Good afternoon. The following comments are provided in respect of the subject modification proposal:

DRAWING TITLE  
**ELEVATION NORTH & SOUTH**

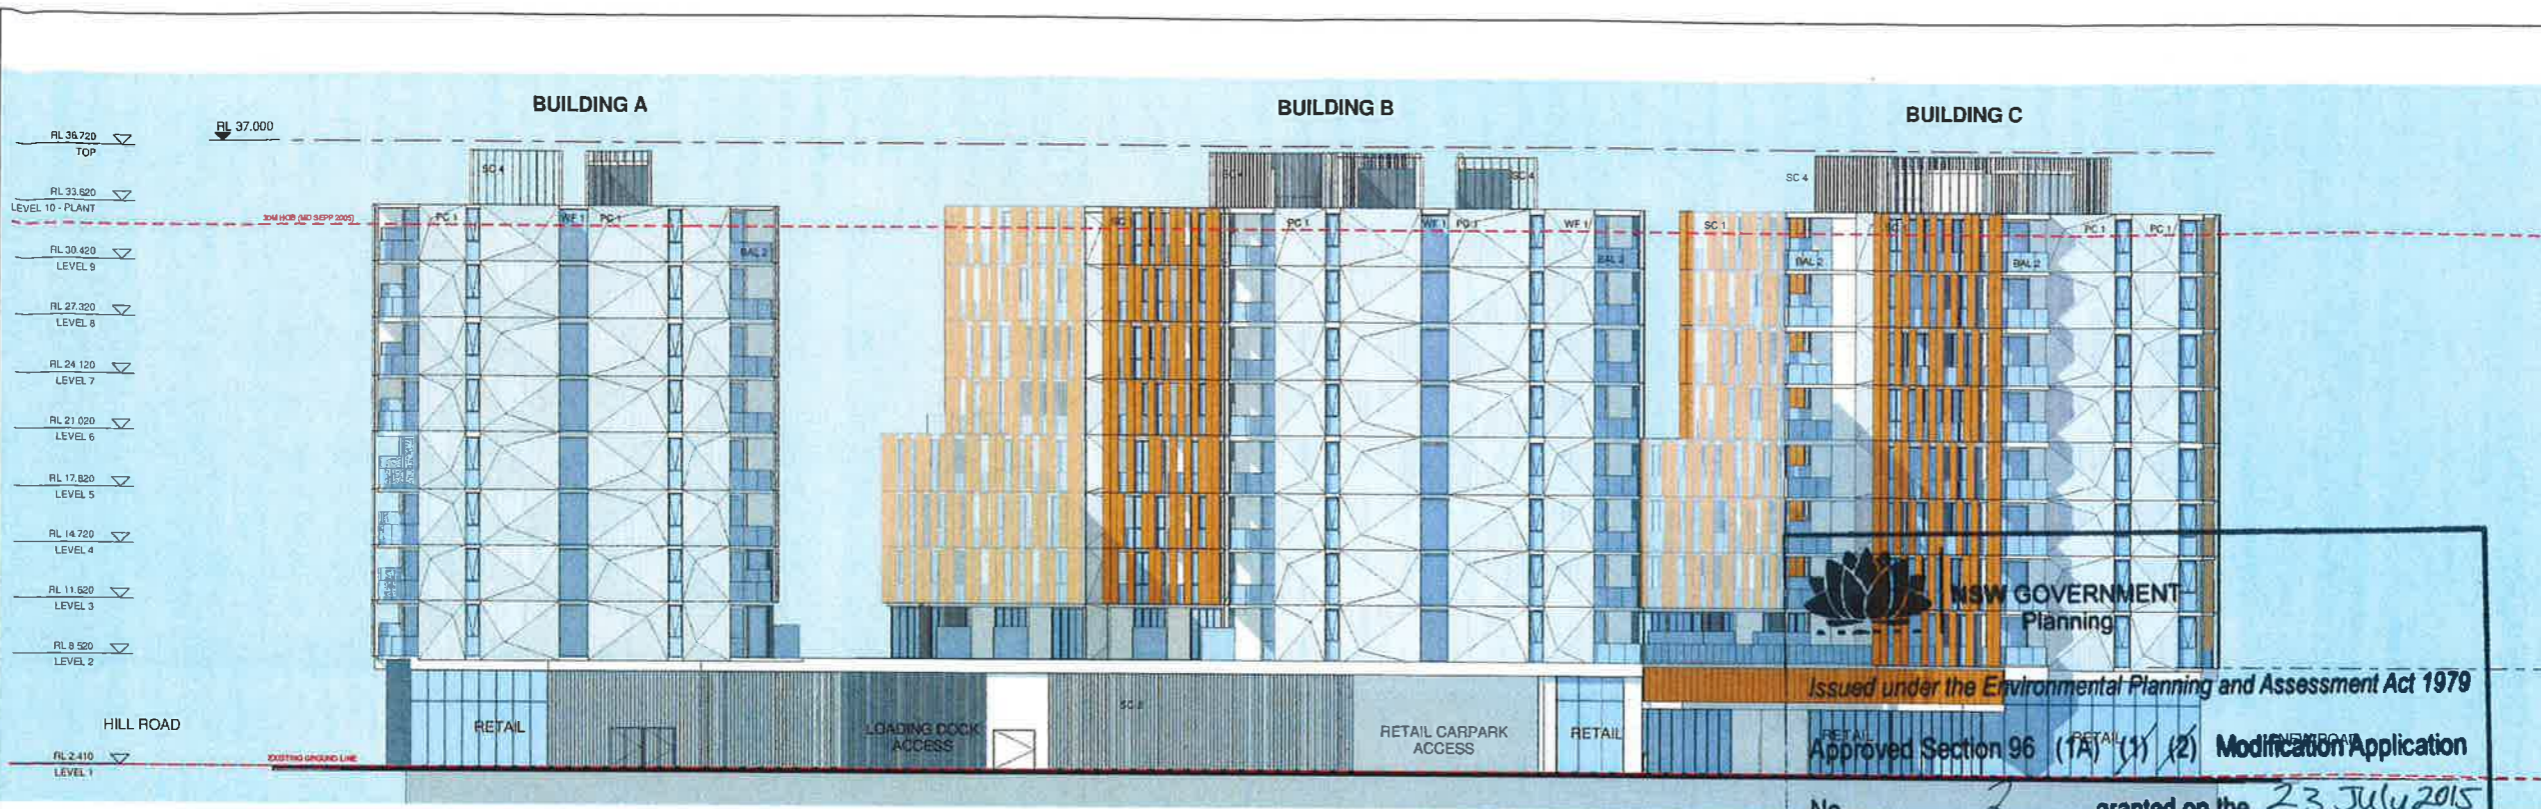
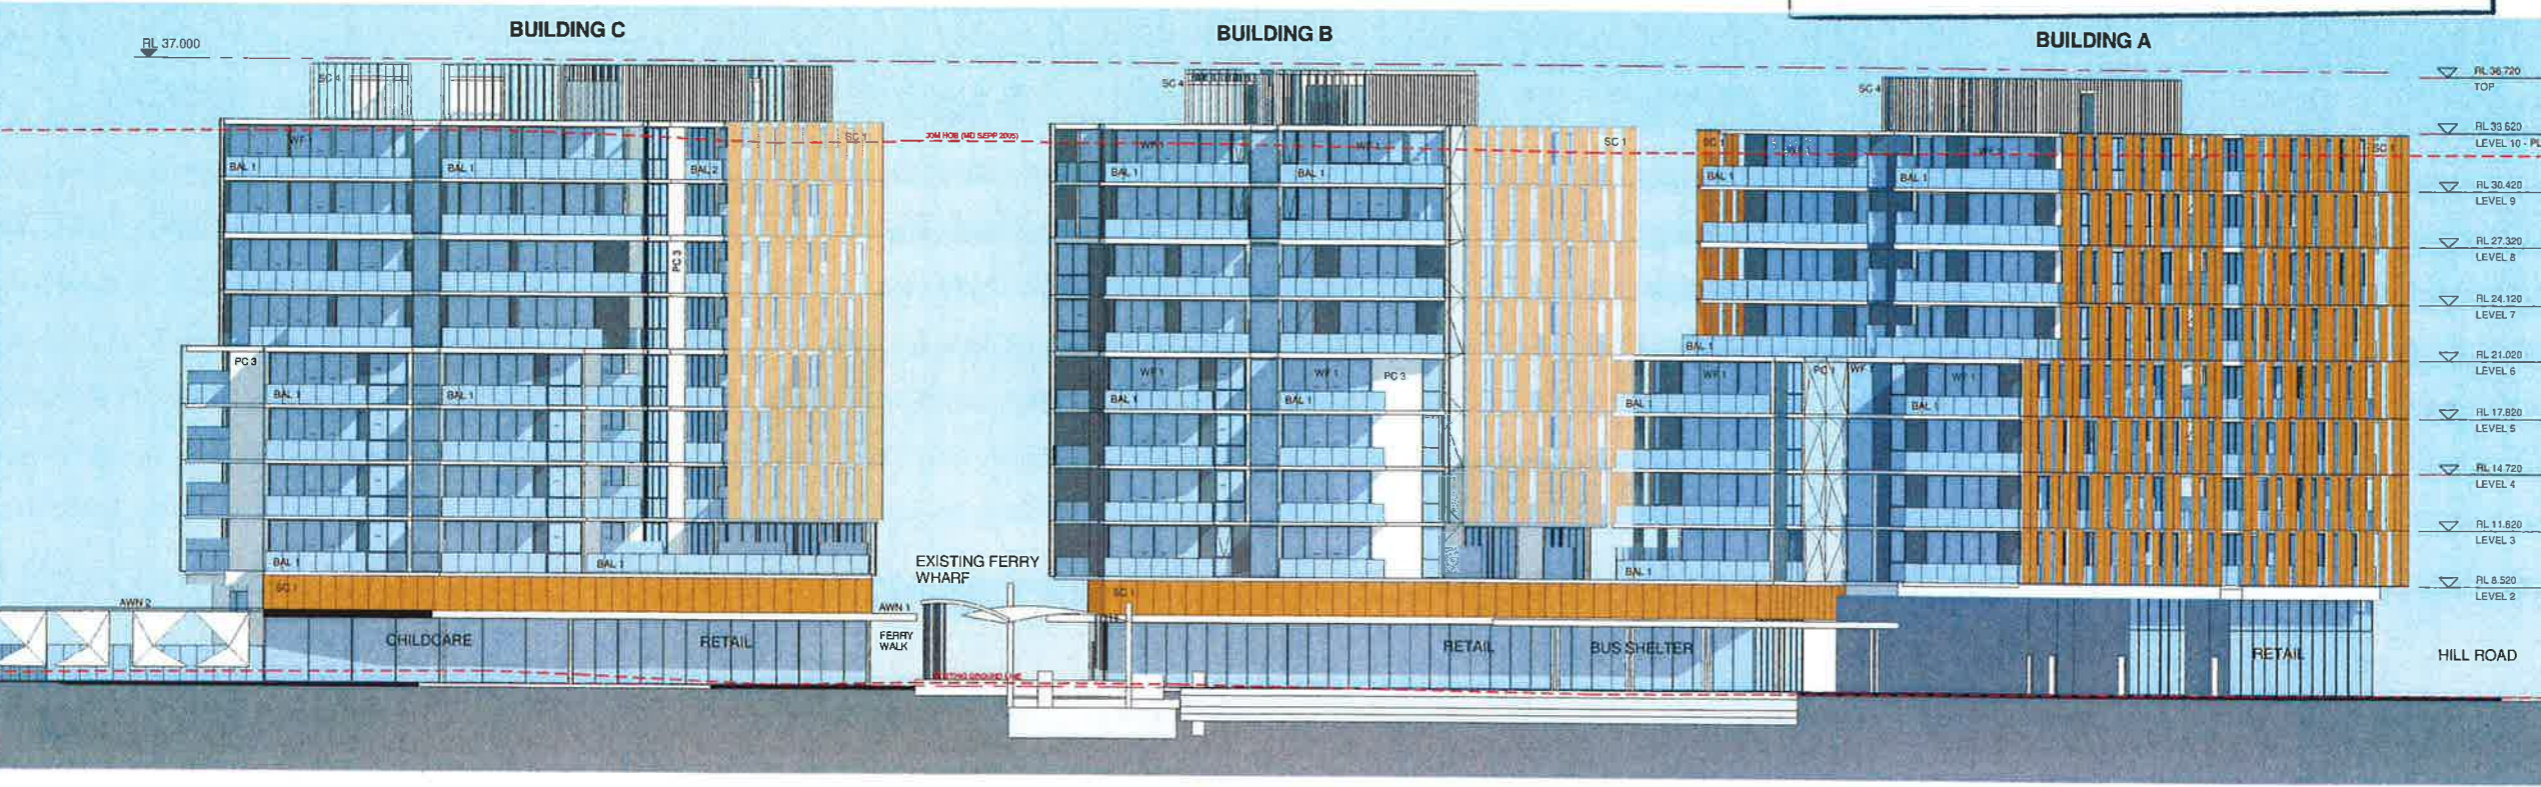
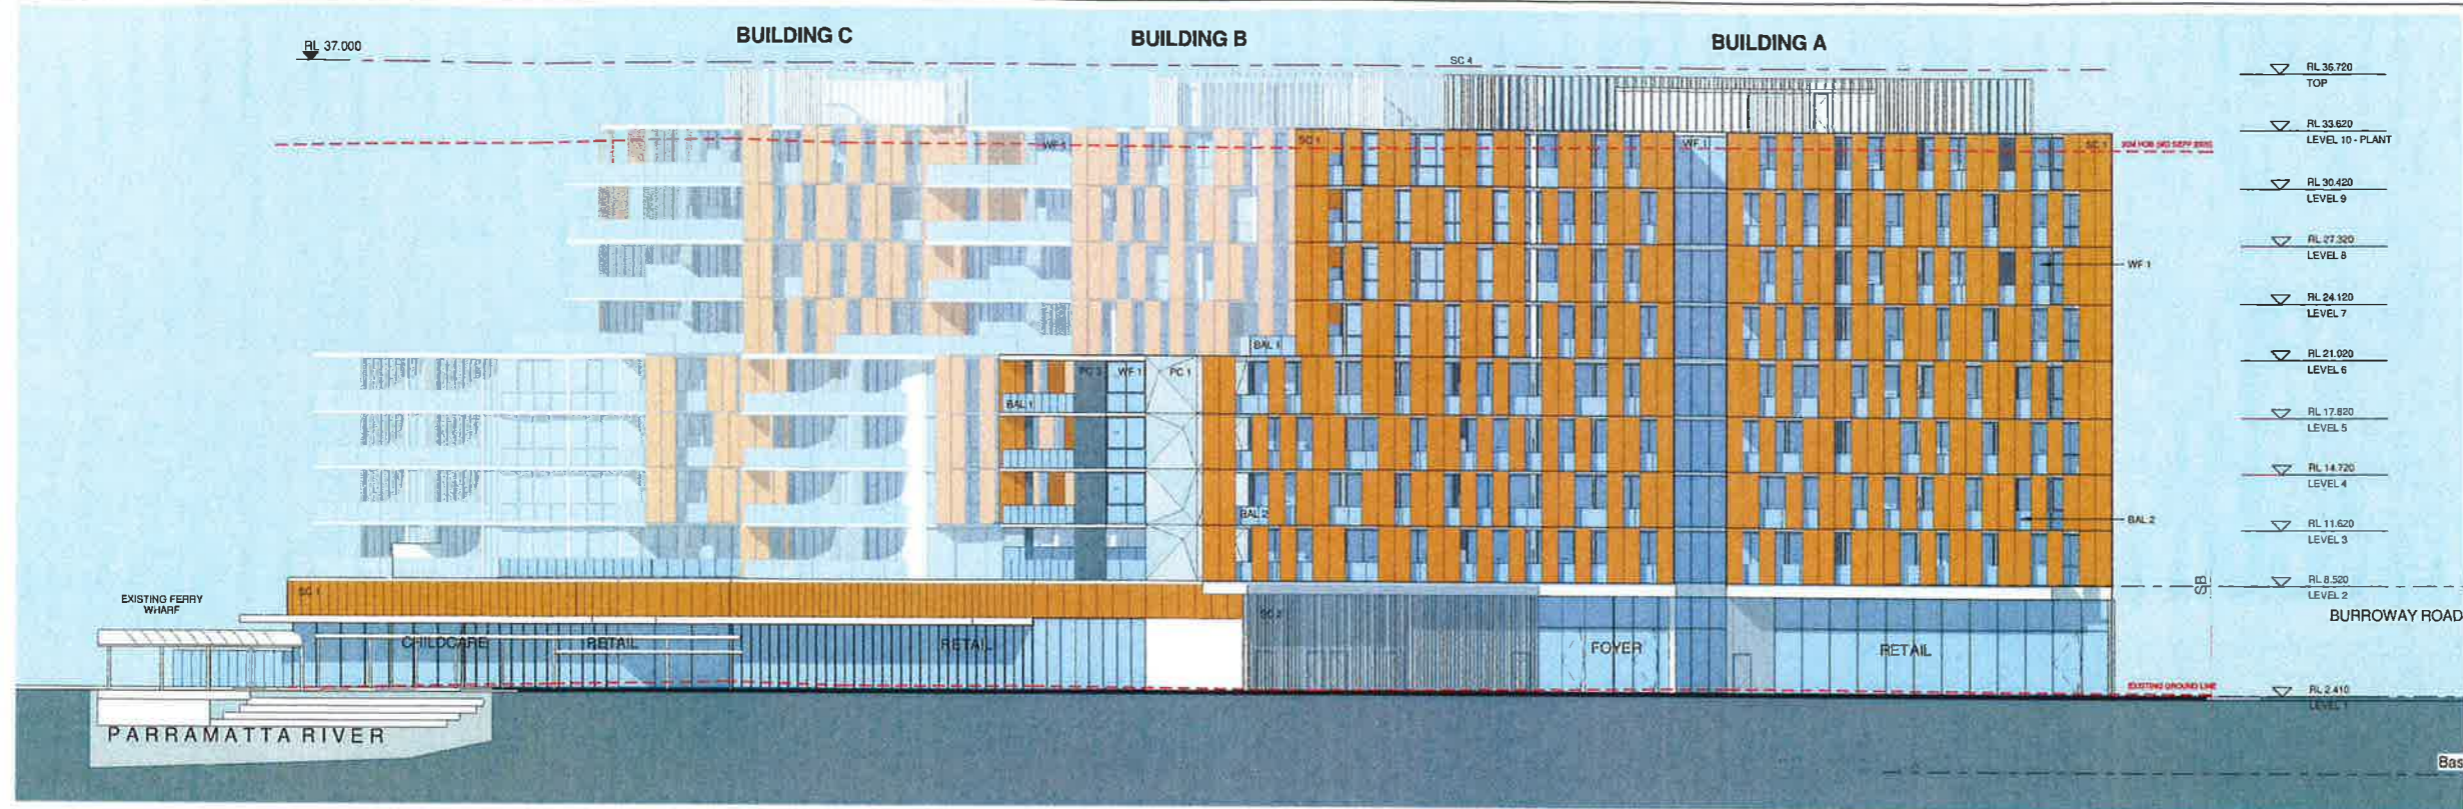
- Façade changes should incorporate durable, low maintenance materials and should make a positive contribution to the architectural merits of the building.

DRAWING TITLE
**TYPE B PRE & POST ADAPTATION
PLANS**

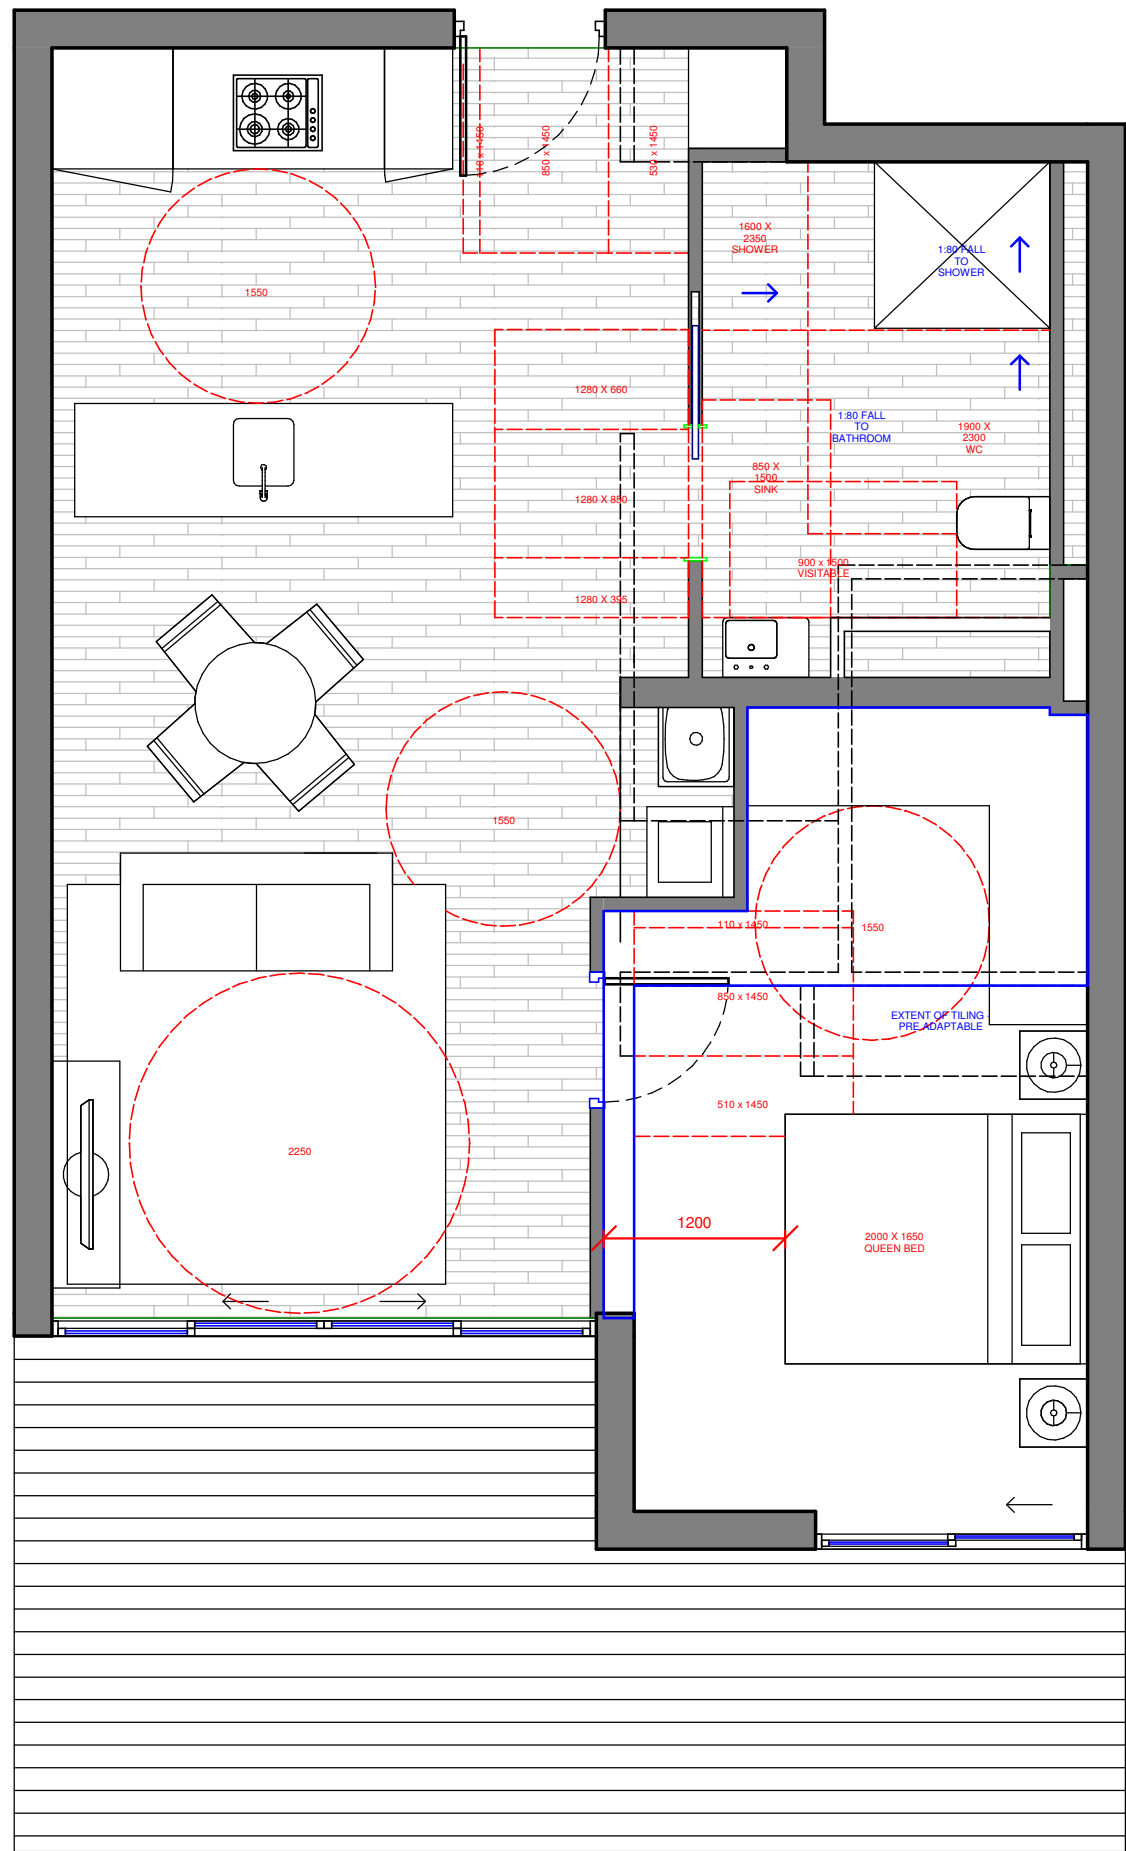
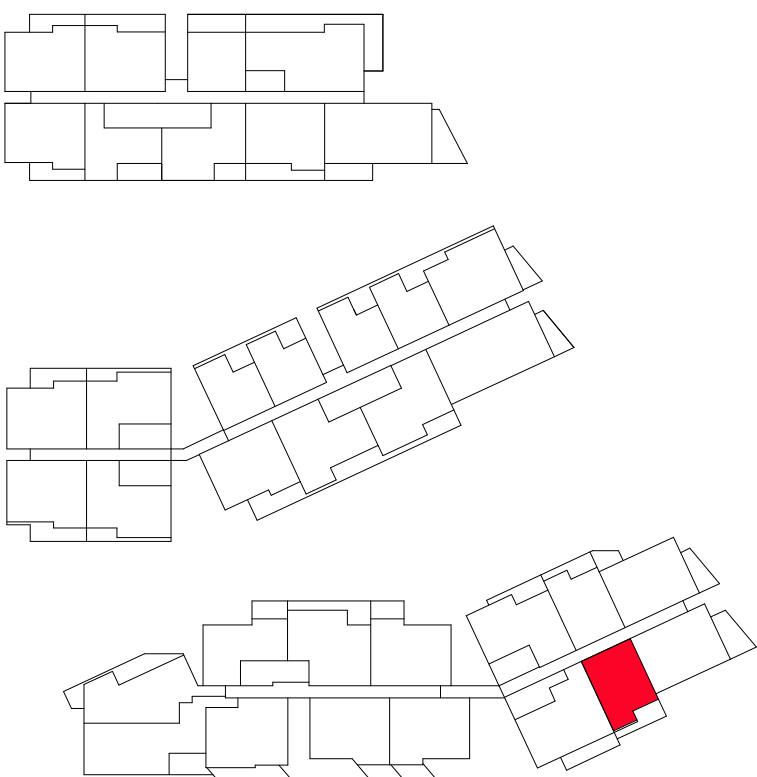
- Consideration should be given to providing accessible parking spaces to support the Adaptable apartment being proposed. Reference should be made to Australian Standard AS28890.
